Pear tree Hill Solar Farm

Response to Deadline 3 Submissions and Other Submissions

Application Document Ref: EN010157/APP/8.18
October 2025

Figure 14.2: Transport Routing and the Existing Highway Network

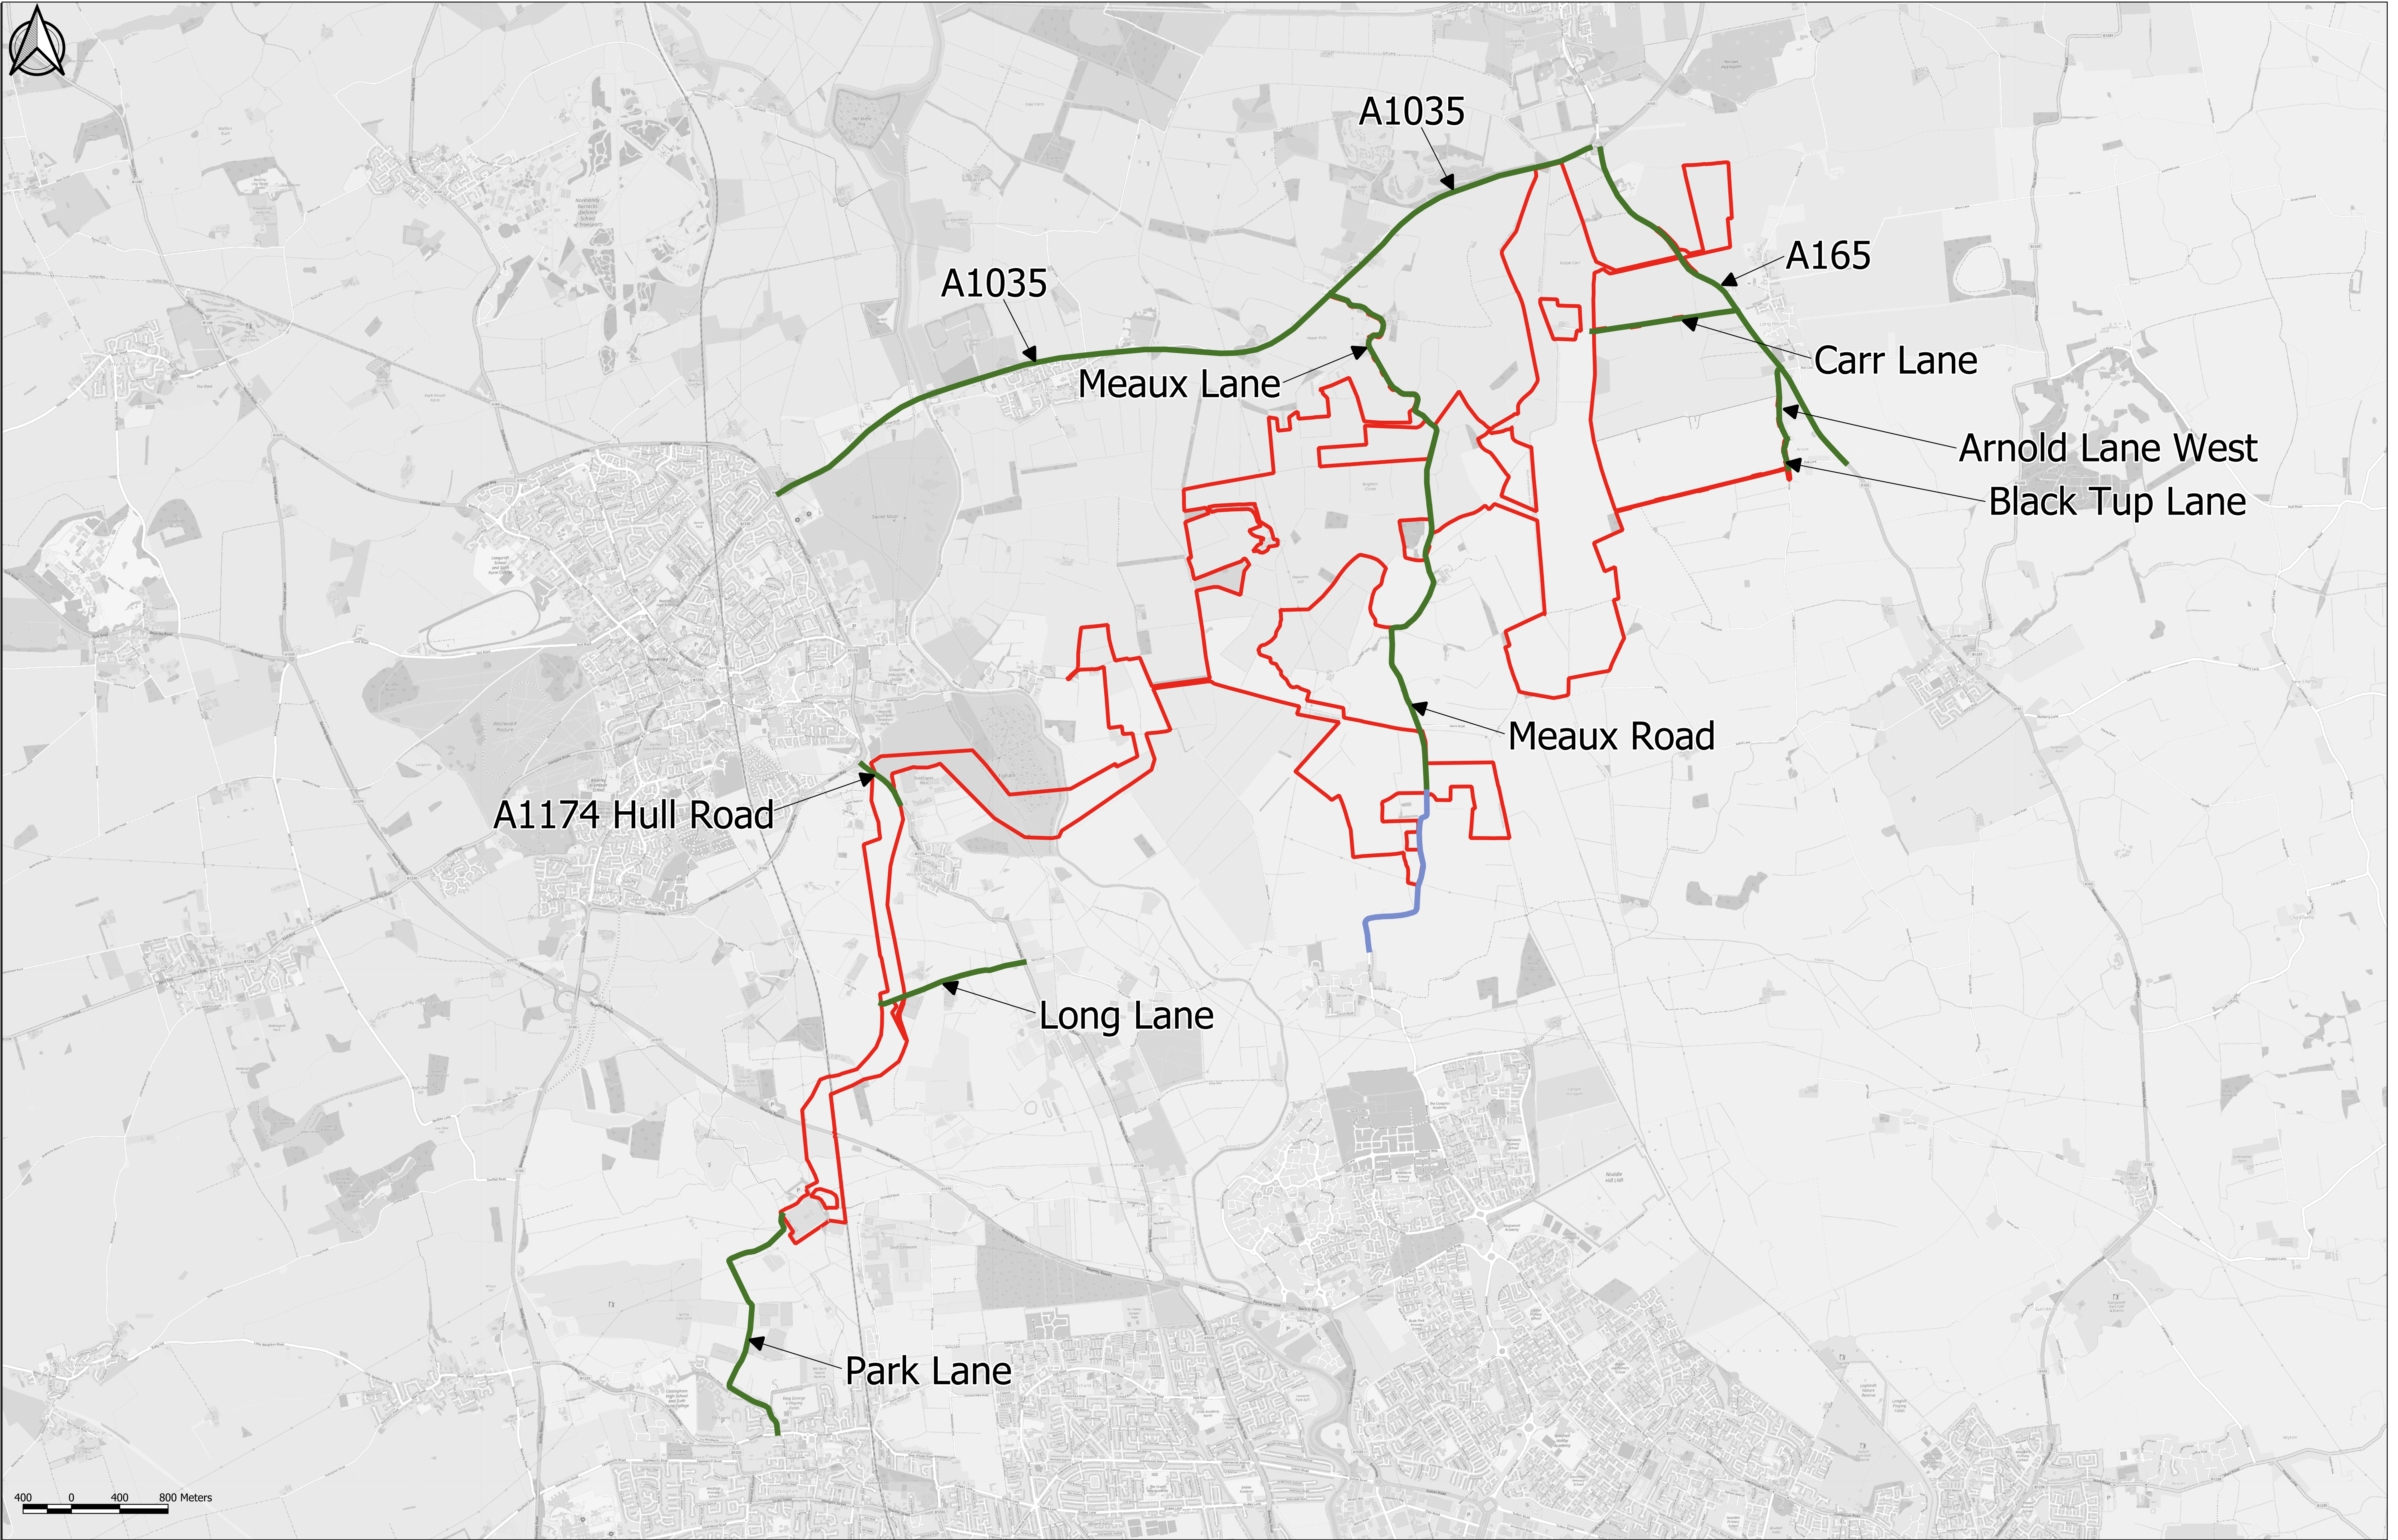
2.13.1	<p>Use of Park Lane during construction The applicant has responded (on pages 19 and 20 of [REP2-037] and pages 71 to 74 of [REP2- 038]) to your concerns regarding the use of Park Lane during construction (and has committed to the restriction of the use of this route around school drop off and pick up times (oCTMP paragraph 6.1.8 [REP2-142])). You will also note the</p>	<p>The Proposed Development will require access to the area within the Order Limits adjacent to National Grid Creyke Beck Substation for a short period (approximately 3 months) whilst the cable grid connection works are undertaken. It is anticipated that this will require approximately a peak of 10 HGVs (20 HGV movements) and 10 LGVs (20 LGV movements) per day. As set</p>

Reference	ERYC Response Summary	Applicant Response
	<p>observations in the note of the ExA's unaccompanied site inspection (USI2 [EV1-002])). Please:</p> <p>a) Confirm whether the applicant's response addresses your concerns, and if not, the reasons for this;</p> <p><i>The response does not address or satisfy the council in terms of its concerns regarding the use of Park Lane and the PROW.</i></p> <p>b) If it does not address your concerns, clarify, with supporting evidence your views on the severity of any impact/ effect, noting that the LIR states at paragraph 7.74 that '[...] the use of Park Lane could have significant impact [...]' whereas paragraph 7.114 states 'It is considered it would have a negative impact on highway safety and residential amenity [...]', and is thus not clear on the matter; and</p> <p><i>The most recent seven-day traffic count that has been undertaken by ERYC located near on Park Lane near Henson Drive in September 2020 which identified an HGV rate of 0.2% of average daily trips of 1154. This equates to an average of less than 3 two-way HGV movement per day. Therefore, any increase that may be considered modest along Northgate would be considered fairly significant along this section of Park</i></p>	<p>out in the Outline CTMP [EN010157/APP/7.7 Revision 5], the Applicant would restrict HGVs to routing on Park Lane, Harland Way and Northgate outside of local school drop-off and pick-up times. the Applicant would restrict HGVs to routing on Park Lane, Harland Way and Northgate outside of local school drop-off and pick-up times.</p> <p>The Outline CTMP [EN010157/APP/7.7 Revision 5] sets out measures which are proposed to be implemented in order to mitigate potential highway safety related issues as a result of construction traffic routing via Park Lane.</p> <p>The CTMP will confirm the details of traffic measures.</p> <p>Additionally, measures are set out in the Outline Rights of Way and Access Management Plan (RoWAMP) [REP2-144] for the careful management of PROW (including Riston Footpath 17 which is located on Park Lane) using temporary closures and bankspeople. The RoWAMP will confirm the</p>

Reference	ERYC Response Summary	Applicant Response
	<p>Lane. The traffic count information is submitted as Appendix A.</p> <p>The Visibility at the Junction with Park lane and Northgate is very limited due to existing dwellings and the tight radii (See figure 1). The Departure side (left is acceptable and complies with Manul for Streets, however the arrival side (right) is very restricted and only has 2.4 x 18m visibility splay to the nearside kerb and does not comply with the 2.4 x 43m for a 30mph speed limit. An OS based drawing showing the visibility splay is shown in Appendix B.</p>  <p>Figure 1: Arrival side junction visibility looking west along Northgate from Park Lane</p>	<p>details of measures for managing PRow users and construction traffic.</p> <p>It is understood that Park Lane will be used for construction vehicle routing associated with the consented Creyke Beck Battery Storage and Solar Farm site (23/03926/STPLF) with a total of 2,004 HGV movements anticipated across the construction phase (as set out in their CTMP) which equates to an anticipated daily maximum of 40 HGV movements along Park Lane (comprising 20 HGV arrivals and 20 HGV departures).</p> <p>Following ongoing discussions with East Riding of Yorkshire Council, including as part of item 8 of the Issue Specific Hearing 2 [EV6-002], the Outline CTMP [EN010157/APP/7.7 Revision 5] has been updated to state the following: “The Applicant will explore the use of an alternative access which is planned to be created off the A1079 and is associated with the construction of the Wanlass Beck substation as an alternative to the proposed access on Park Lane, should the access off the A1079 have been constructed and made operational, at an appropriate time to avoid disruption or delay to</p>

Reference	ERYC Response Summary	Applicant Response
	<p>The junction is so constrained that limited number of HGVs that typically use this junction over run the footpath due to the tight radii on the western side of the junction, see figure 2.</p>  <p>Figure 2: Damage to Kerbing and footpath due to HGV overrun on Park Lane Junction</p> <p>Park lane itself is heavily populated and at times can become constrained due to resident parking and the horizontal alignment of the road, an example of this is shown in Figure 3. There are also access points to King George V Playing fields, where young children enter and exit Park Lane.</p> <p>Following discussion with the PROW team it was acknowledge that the Park Lane PROW is one of the Councils heaviest utilised PROWS especially for those</p>	<p>the construction programme of the Proposed Development and subject to all necessary agreements and rights being able to be obtained to use the access.” The updated Outline CTMP [EN010157/APP/7.7 Revision 5] is submitted at Deadline 4.</p>

Reference	ERYC Response Summary	Applicant Response
	<p>It is the Local Highway Authorities opinion that give the details outlined above the development could have an unacceptable impact on highway safety. This is specifically in relation to the use of the Park lane/Northgate Junction and the sue of the PROW as a haulage route.</p> <p>If the inspector is minded to allow the use of Park Lane for construction the council would like to see further restrictions such as construction traffic along park lane is only permitted between 09:30- 15:00, avoiding the school and network traffic peaks.</p>

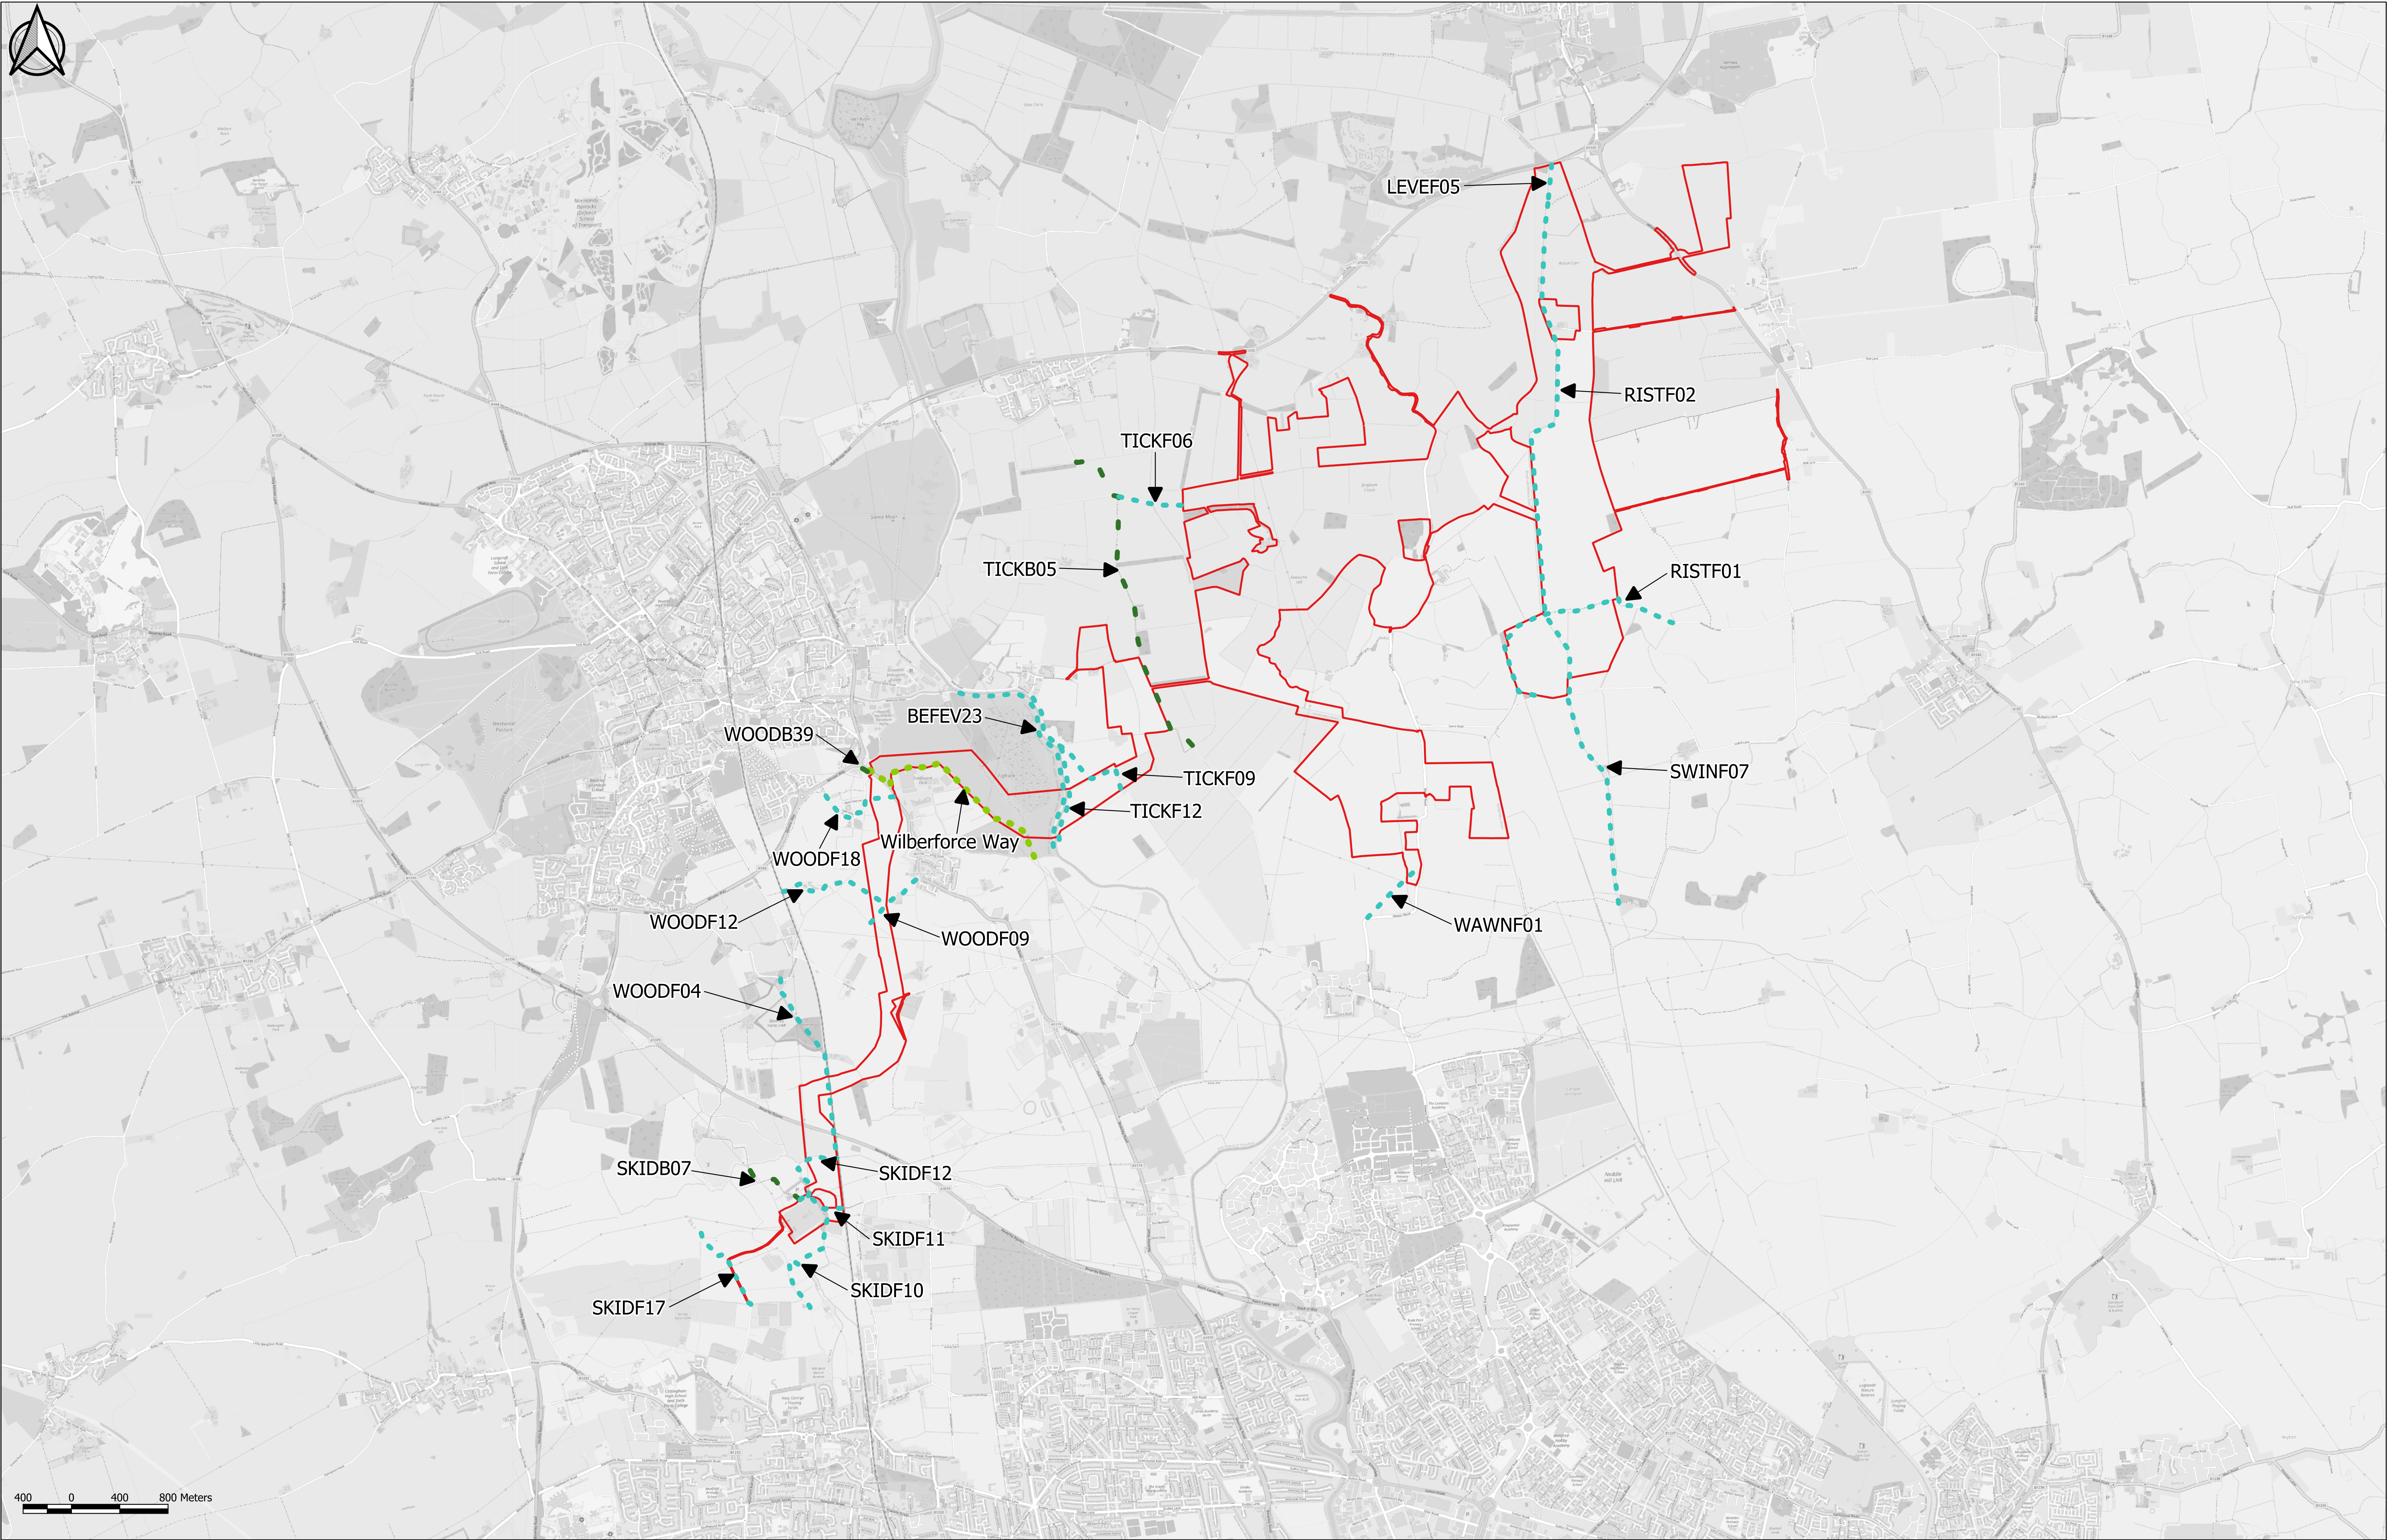
2.10.4	<p>Mitigation</p> <p>The applicant has responded [REP2-037] to the LIR (including paragraphs 7.185, 7.189, 7.295) in respect of ERYC’s suggestion for additional planting along the southern boundary of field F13 to address effects for users of ‘Swine PROW’ (which the ExA understands refers to footpath SWINF07). The applicant notes there is already a hedge in this location and in other fields and due to this, and distances involved, views of the proposed development from this PROW, and one to the south (which the ExA understands to be WAWNB10)</p>	<p>A meeting was held between the Applicant and the East Riding of Yorkshire Council landscape consultants on 28 October 2025. It was agreed that the minimum heights of screening hedgerows (as set out in the Outline LEMP [EN010157/APP/7.5 Revision 7]) would be maintained when they are trimmed, so they would be maintained in the region of 3-3.5m in height. This agreement has been captured in new item ERYC36b of the Draft Statement of Common Ground with East Riding of</p>

Reference	ERYC Response Summary	Applicant Response
	<p>would be limited. Please confirm whether this alleviates your concerns, and if not, explain why.</p> <p>The detailed local knowledge of the applicant is appreciated in respect of identifying existing hedgerow cover. We also note the proposed approach in [REP2-037] “as a hedgerow on the site boundary the height of the hedgerow would be allowed to grow by reduced hedgerow flailing” which is confirmed in LVIA [APP-048] para 11.4.32 “It has been assumed that, where necessary and appropriate for the mitigation of landscape and visual effects, any existing hedgerows adjoining the Site would be repaired/improved with new planting to infill gaps. It has also been assumed that any existing hedgerows adjoining the Site would be maintained at a minimum of 3.5m in height...”. This commitment is confirmed in the LEMP [REP2-140] which states (Table 6.1) “Existing hedgerow trimmed to desired height: Generally existing hedgerows will be allowed to grow to a height of 3.5m. Hedgerows adjacent to Monk Dike will be allowed to grow to a height of 4m. All will be cut on a two- or three-year rotation (different sections of hedgerow being cut each year).” Presumably, this will have the same result as stated for new hedgerows, Table 10- 3 “The established ... hedge is to be maintained at 3- 3.5m high and 2-3m wide.” Given the proposed maximum panel height of 3m, this</p>	<p>Yorkshire Council [EN010157/APP/9.2 Revision 4] submitted at Deadline 4.</p>
